PLANNING DEPARTMENT – Development Review Services

RE: **Copper Pointe  
Grading and Drainage Plan  
Engineer's Stamp Date 9-24-15 (File: K21D009H3)**

Based upon the information provided in your submittal received 9-25-15, the above referenced Grading and Drainage plan cannot be approved for Paving Permit until the following comment is addressed:

INFILTRATION TRENCH DETAIL

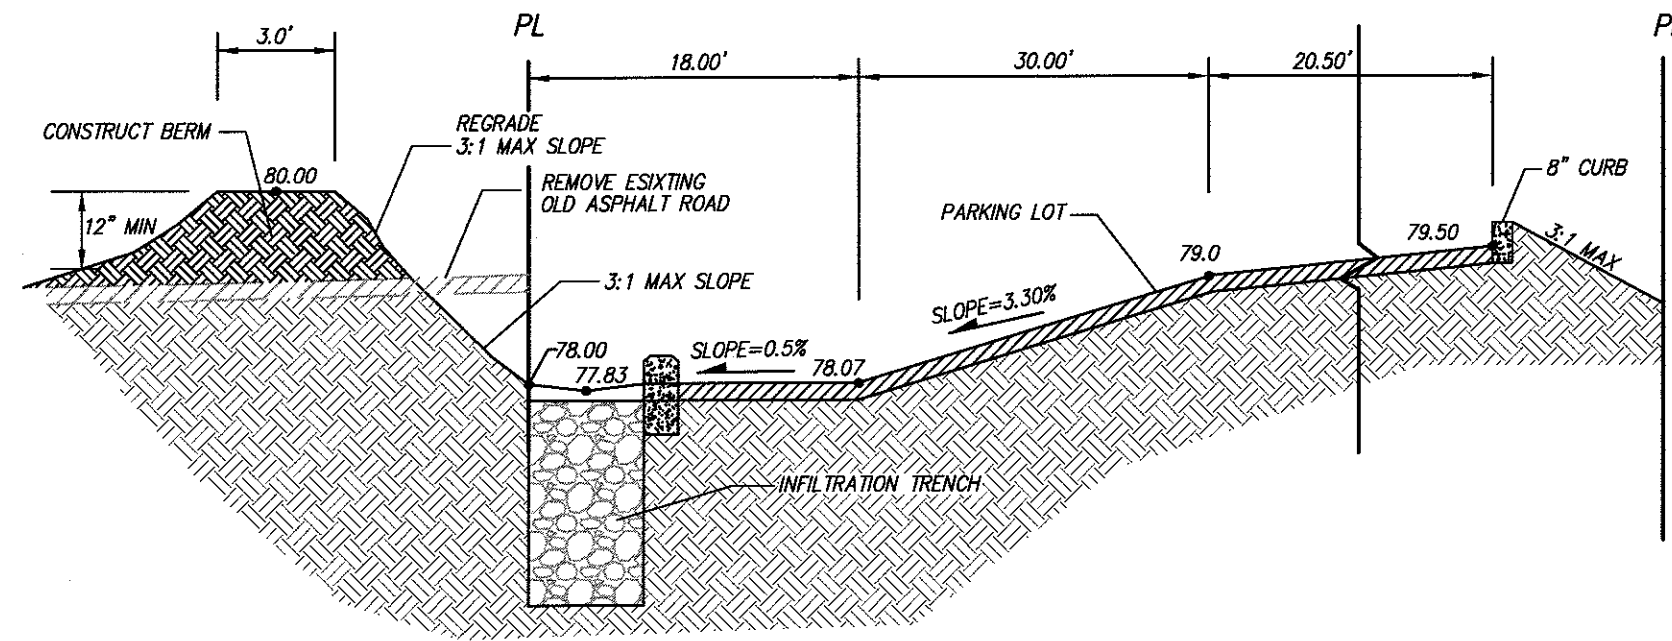
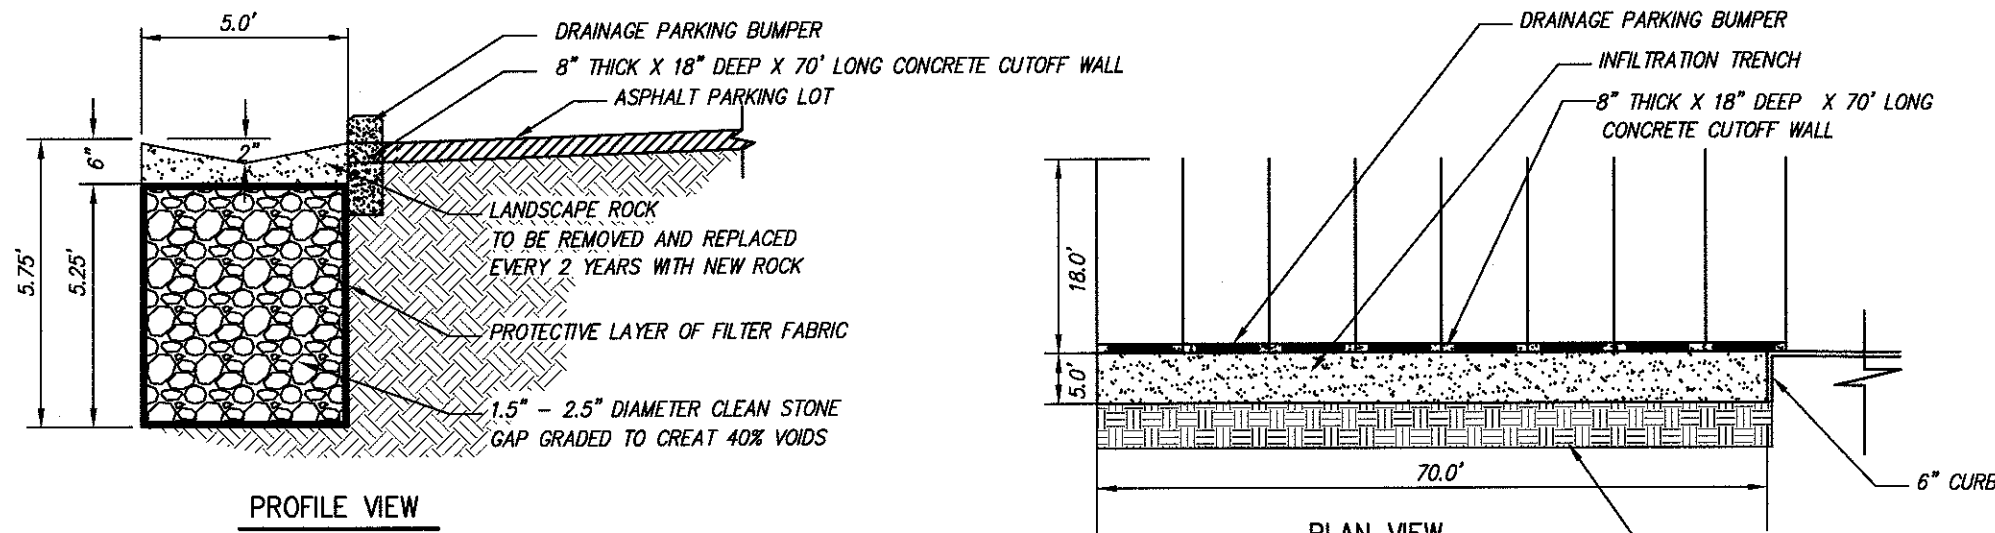
1. The first flush volume is shown to be bled into an existing 96" storm drain. The first flush needs to be retained on site, in a manner that infiltrates to the subsurface.
